Approval of details reserved by condition imposed under LU/182/18/PL relating to conditions 8-details showing set up during construction, 11-surface water drainage & 12-existing and resulting ground levels & slab levels of buildings.

46A & 46B Pier Road Littlehampton BN17 5LW

Arun District Council have decided to **REFUSE details reserved by condition for the following reasons:**

TITLE: Surface Water Drainage Strategy - Proposed Layout

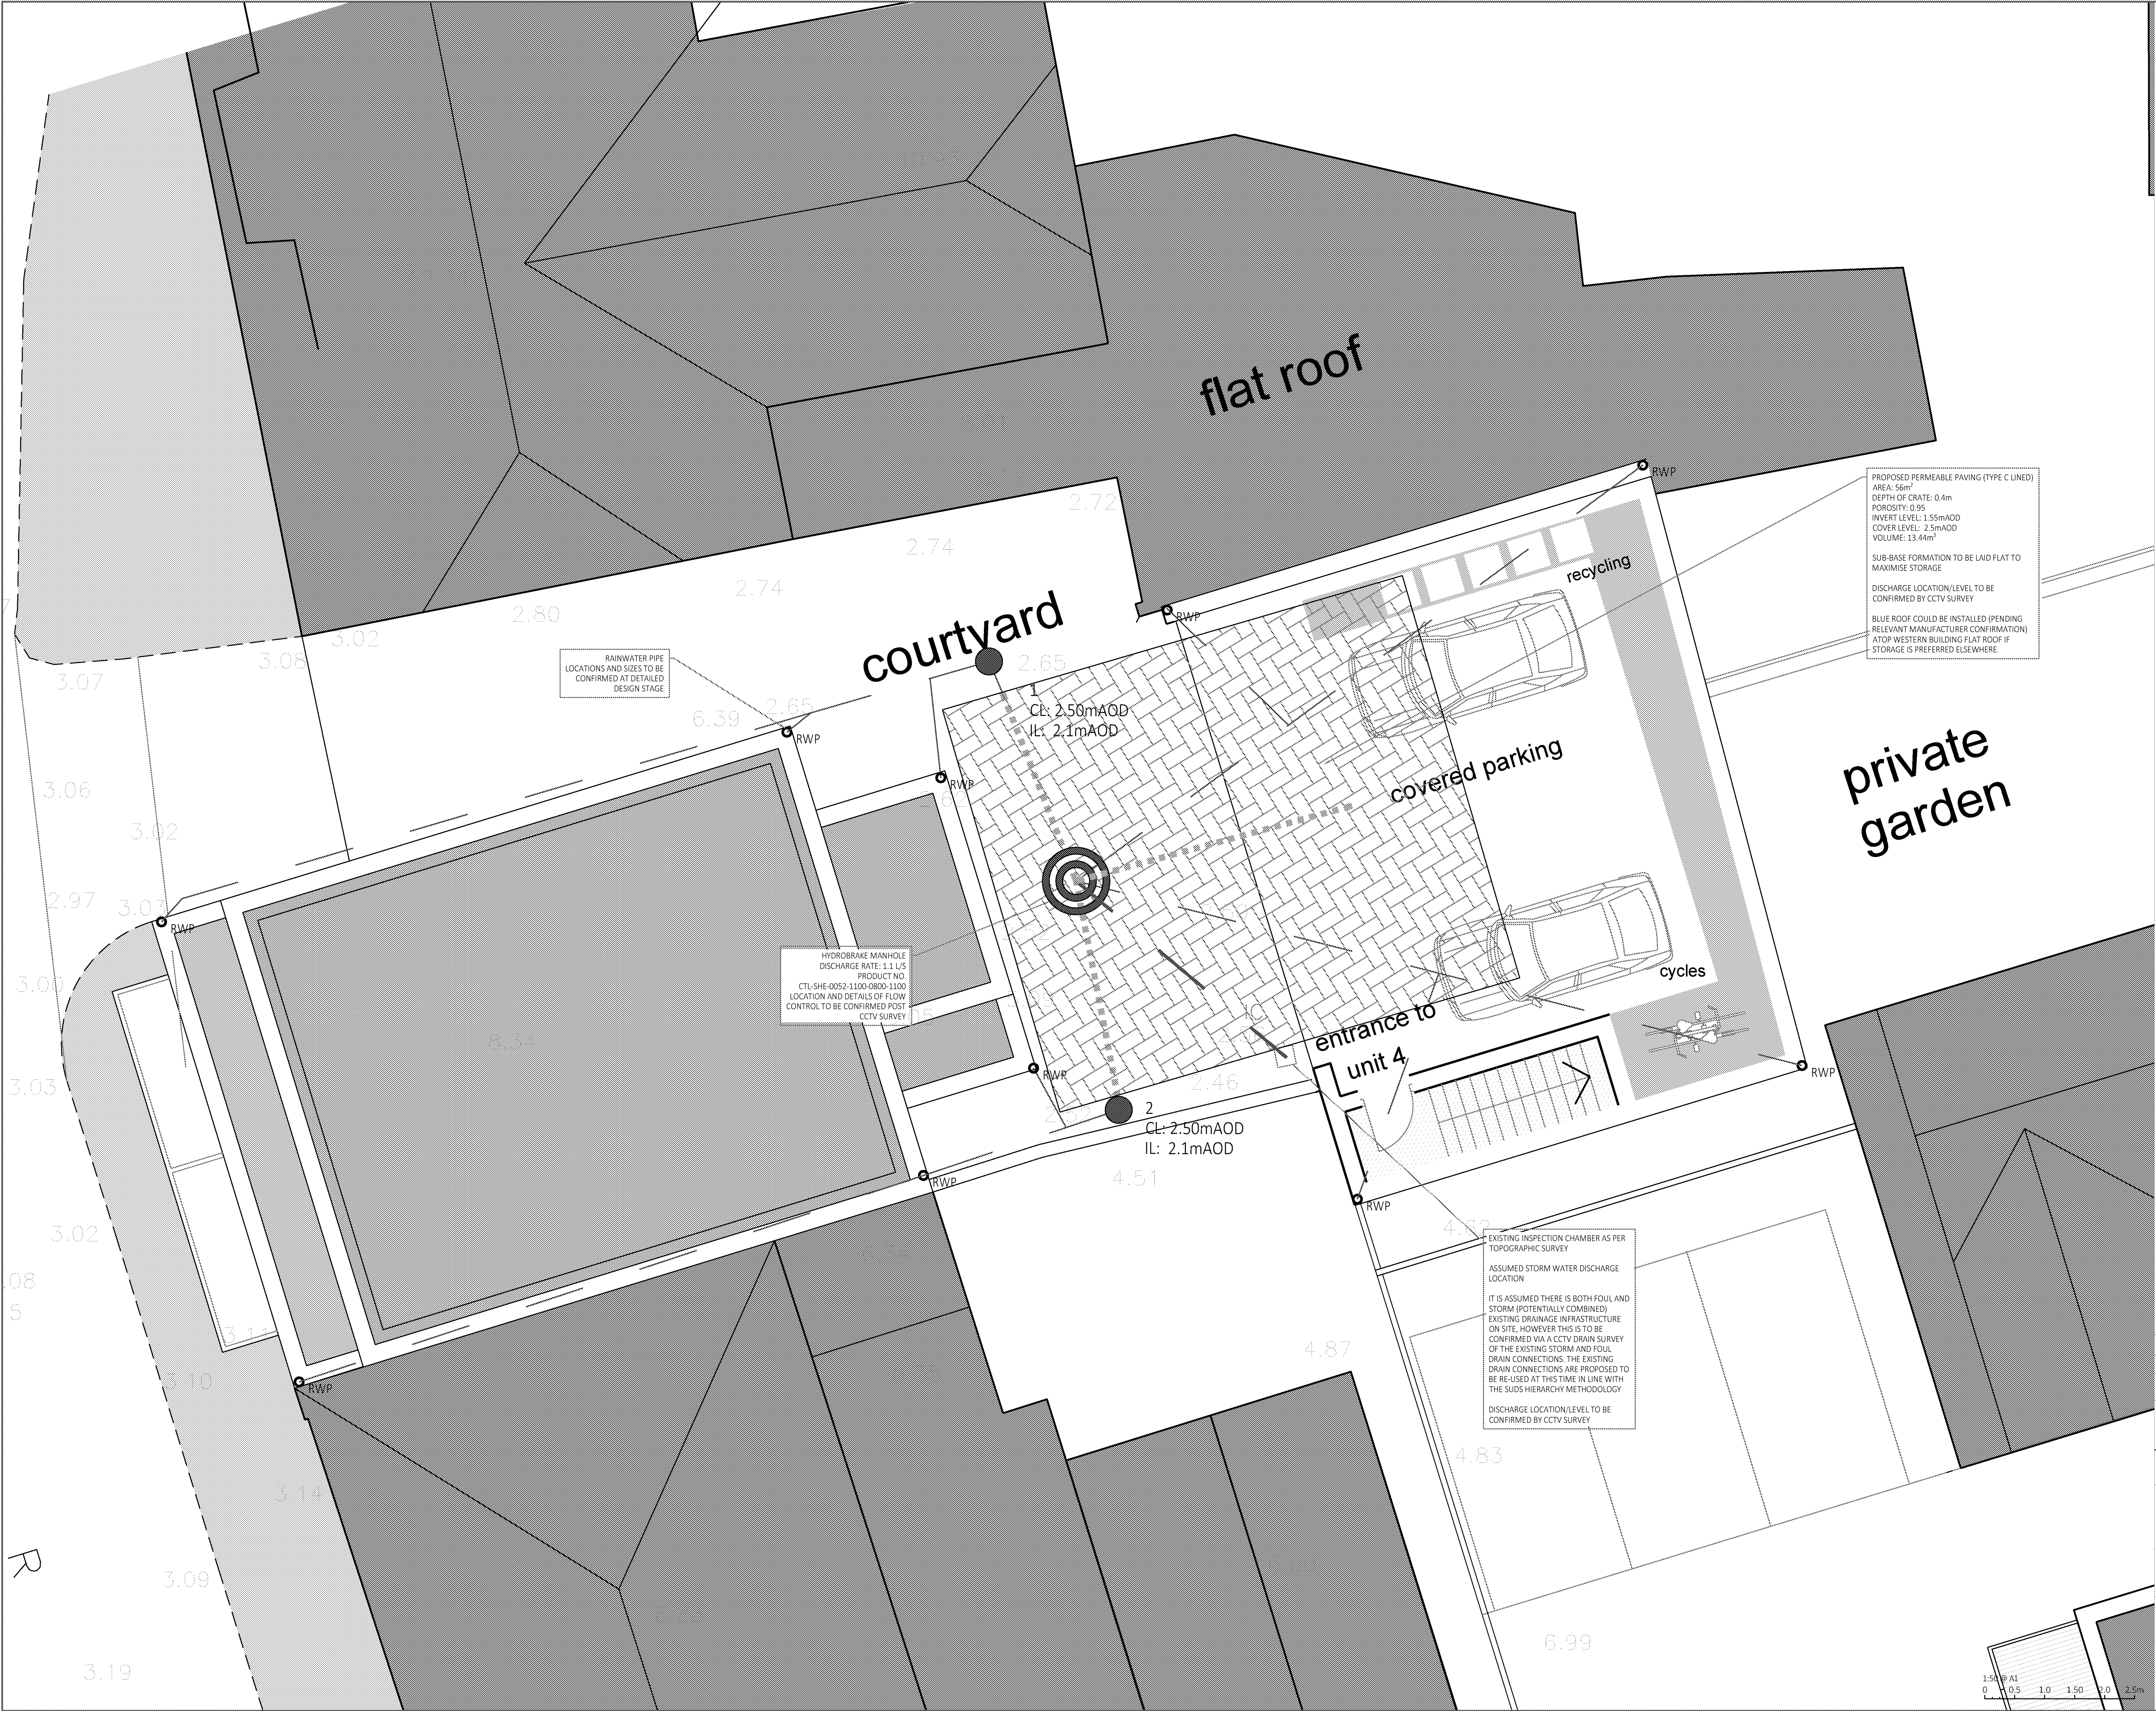
2.Catchpits must be provided upstream of connections into permeable paving sub-base/ attenuation crates.

3.Pipes must be labelled with pipe diameter and fall.

4.Details must show which drainage solution is proposed, not options.

5.Details of location of proposed connection to surface water sewer must be provided, including invert level.
